DOC20/788417

Senders ref: SSD10396 (City of Blacktown)

**Subject: Notice of Exhibition – Kings Park Metal Recovery and Recycling Facility Expansion located at 23-43 and 45 Tattersall Road, Kings Park (SSD 10396)**

Figure 5 - Extent of 2019 Lidar Adopted in Flood Model

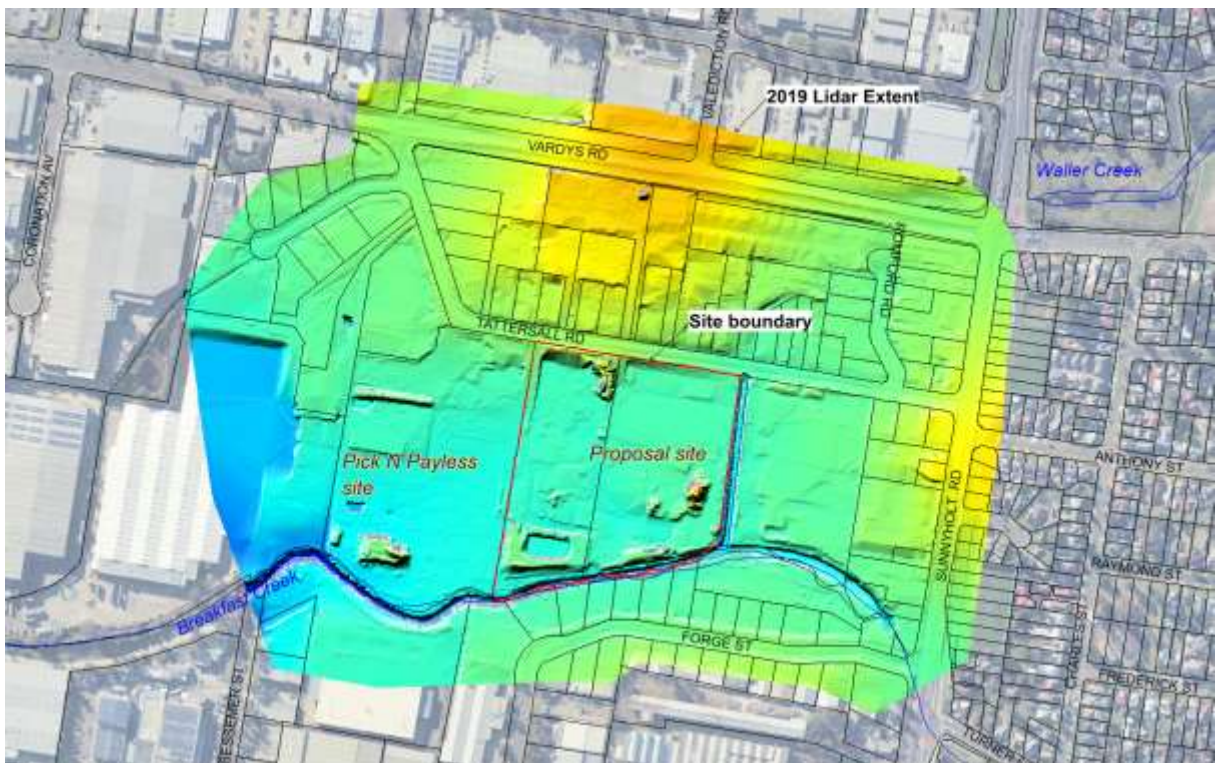
Further EES recommends that Figure 5 will need to be updated with a legend of elevation and Figure 7 with contours of floodwater levels.
